## WEST SUSSEX COUNTY COUNCIL CONSULTATION

| <b>LOCATION:</b>                | Abergail, Clyde Road, Felpham, PO22 7AH                                   |
| <b>SUBJECT:</b>                 | FP/218/19/PL<br>Detached block of 4 x garages.<br>Amended plans received. |
| <b>RECOMMENDATION:</b>          | Advice                                                                    |

SITE PLAN - 1/500

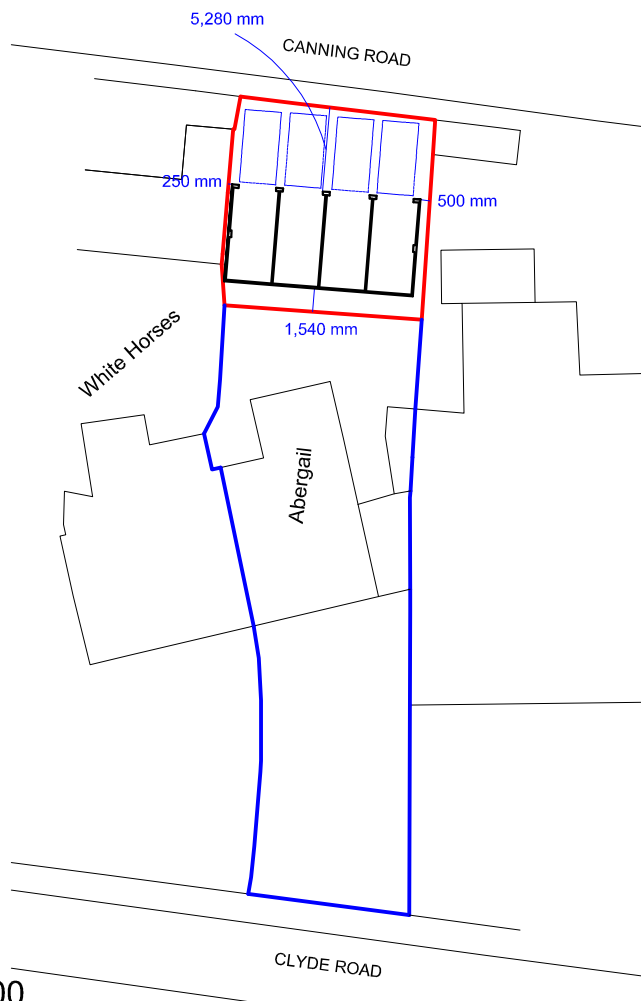
The garages will be accessed from Canning Road. The existing vehicle crossover (VCO) will require widening to formalise the new access, as confirmed by site visit. The VCO will be subject to a licence obtained from the local area office and would be constructed to a specification agreed with the local area engineer. As Canning Road is sided by double yellow lines in this location, no on-street parking would be lost as a result of this proposal.

The site frontage also has sufficient space for hardstanding with 4 additional car parking spaces. The parking bays demonstrated in the plans meet the minimum MfS specifications for single car bays of 2.4m x 4.8m.

Vehicles will not be able to turn on-site and may have to exit onto Canning Road in a reverse gear. However, Canning Road has good forward visibility and neighbouring properties appear to operate similar arrangements with no apparent safety concerns.

No part of the development shall be first occupied until the car parking has been constructed in accordance with the approved site plan. These spaces shall thereafter be retained at all times for their designated purpose.

PROPOSED GROUND FLOOR PLAN

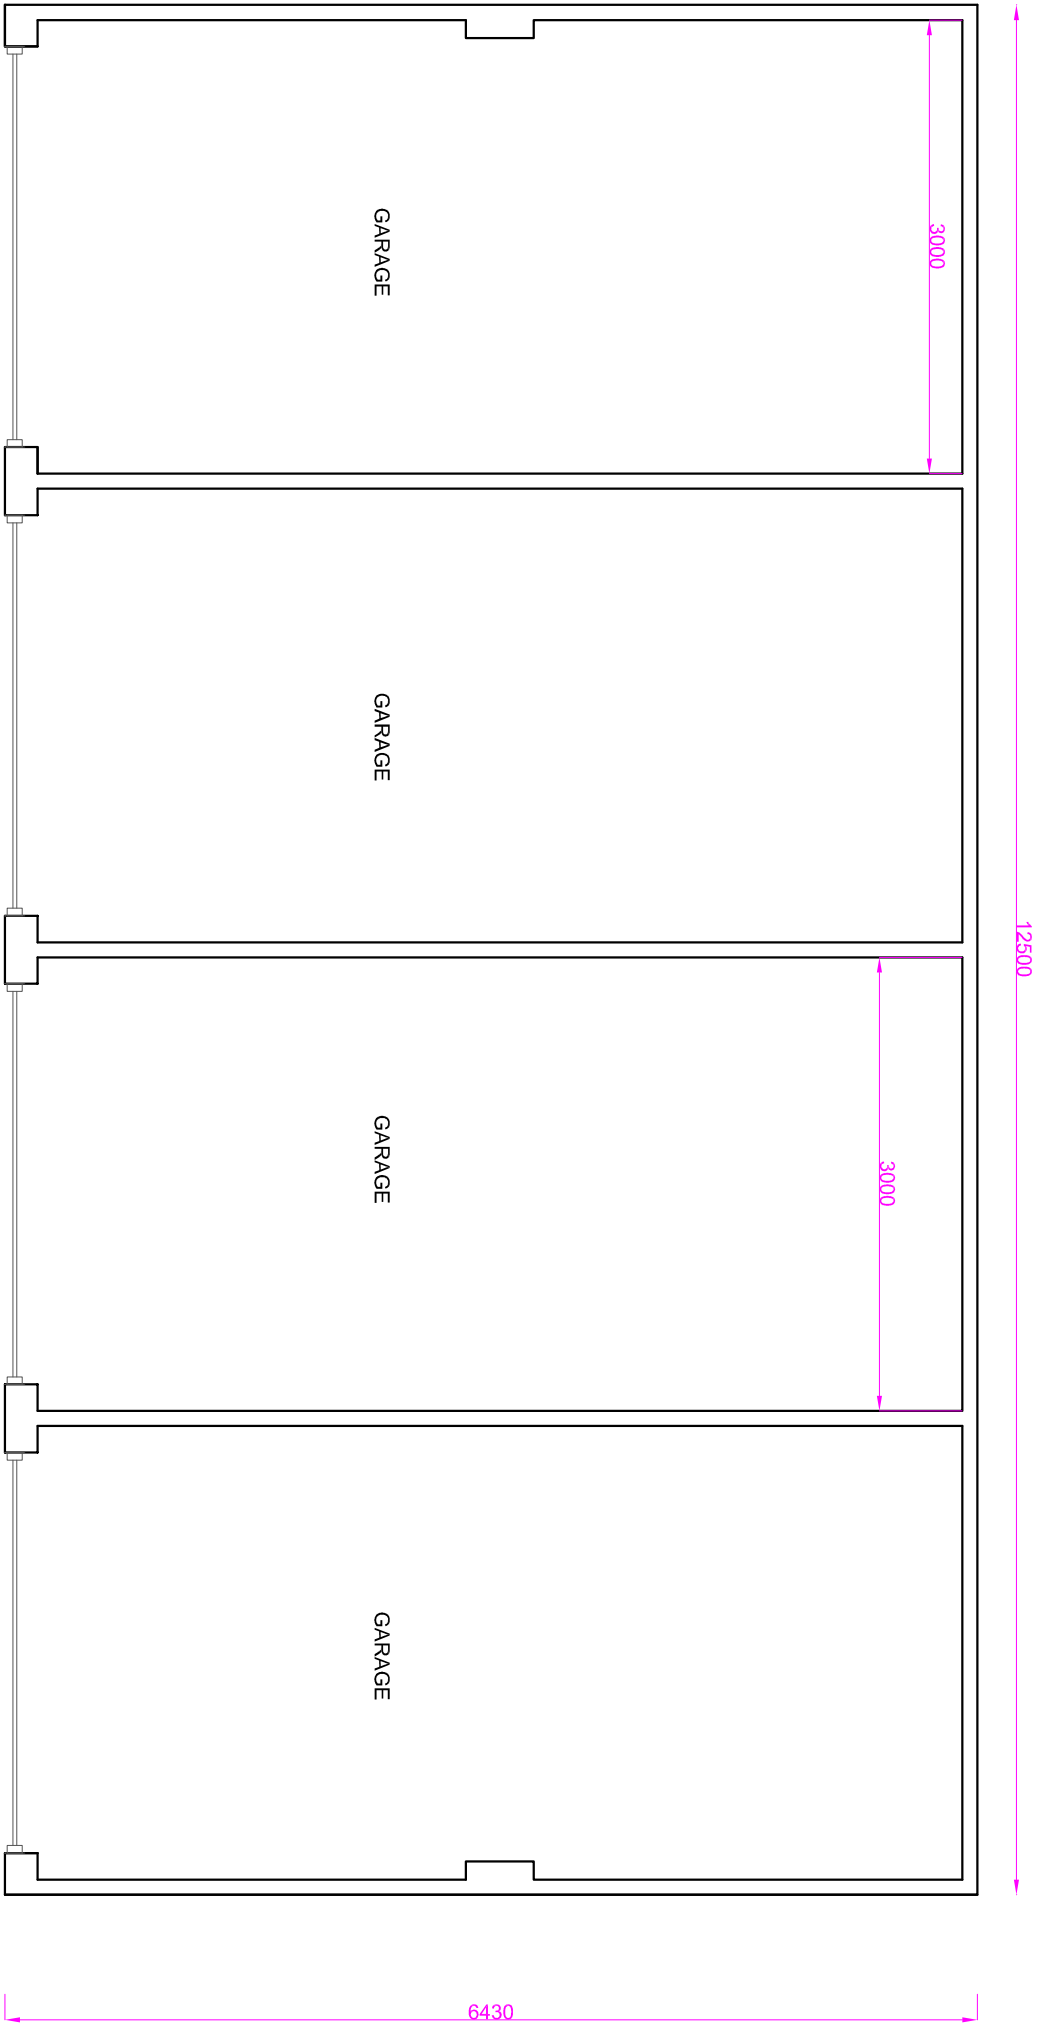
4 single car garages are proposed for this development. The amended plans have demonstrated 4 garages with internal dimensions of 3m x 6.25m. This meets the minimum specifications for single car garages as set out in Manual for Streets (MfS). The garages can therefore be considered for vehicular parking provision as well as cycle parking.
